Re Application No R/141/15/PL Case Officer Mr D Easton

We wish to register our objections to the above proposal submitted by Mr & Mrs Martin of 8 Flint House, Cudlow Gardens, for replacement of balcony railings.

Drawing No:	15/05/2015	Date:	15th MAY 2015
Description:	BALCONY BALUSTRADE	Finish:	GALVANISED, PPC.
Project:	MR MARTIN

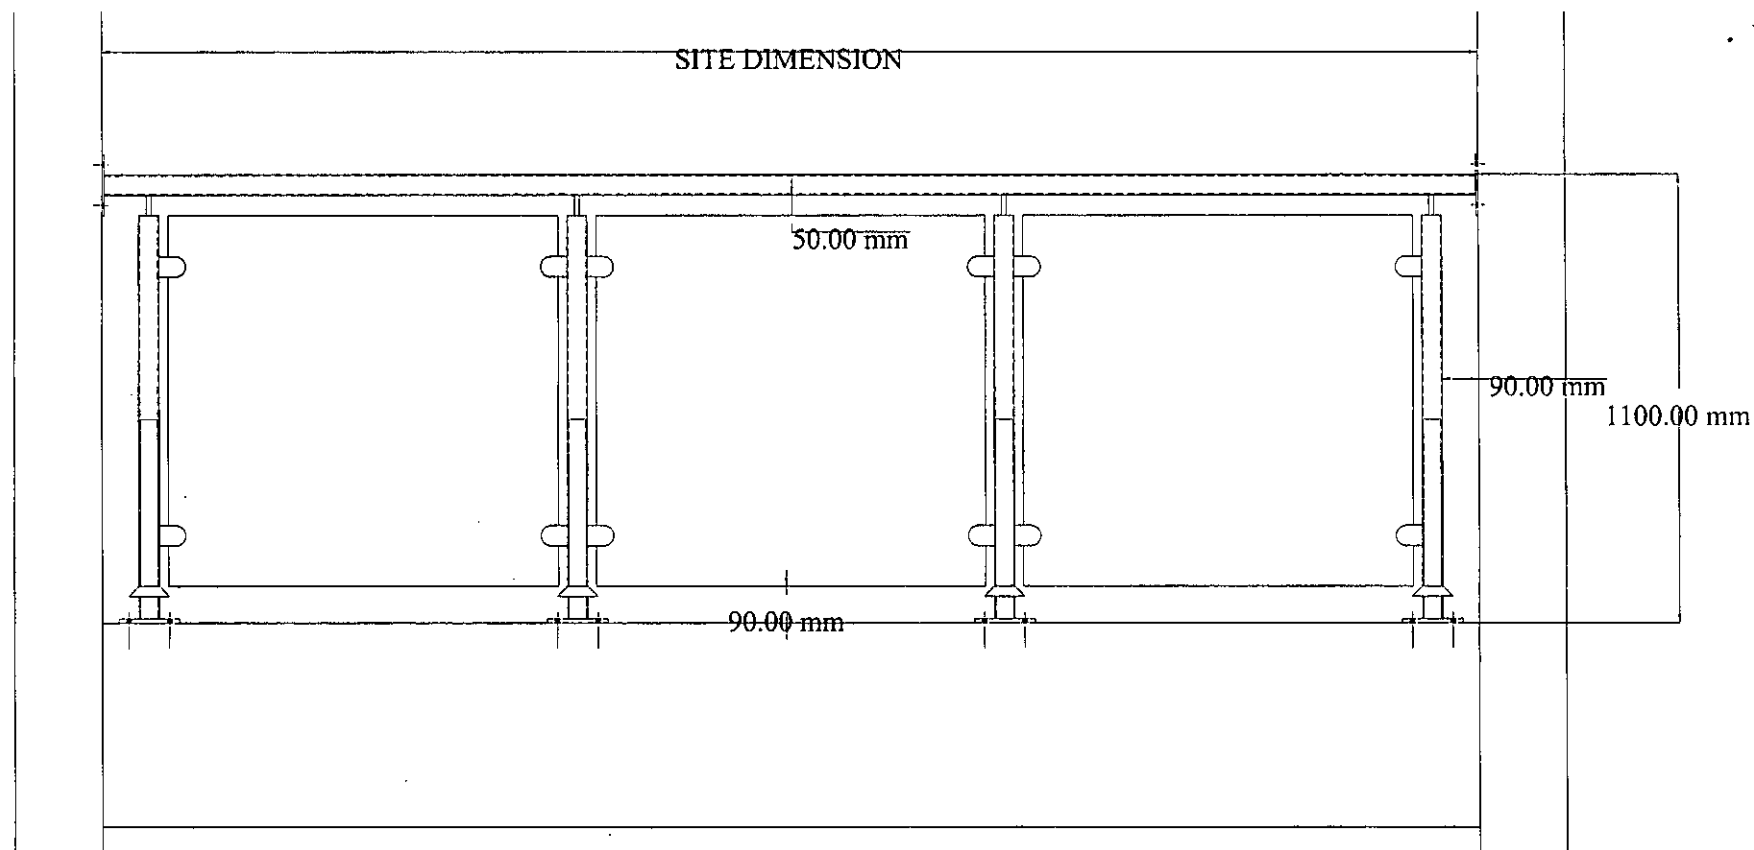
1/ The drawing submitted with the application [Iron Designs] does not represent the actual situation on that balcony because that particular rail extends as a continuous rail across the adjoining flat, whereas the drawing shows it to be self-supporting between two walls. A centre wall does not exist.

2/ It would be unacceptable to have half the length of the existing rail left in the old style, and half in the new proposal: that would frankly look quite ridiculous even if an acceptable method of connection could be engineered with the adjoining owners' permission and agreement. The aspect from Hazel Lodge in particular would be an eyesore and therefore an ongoing and upsetting annoyance.
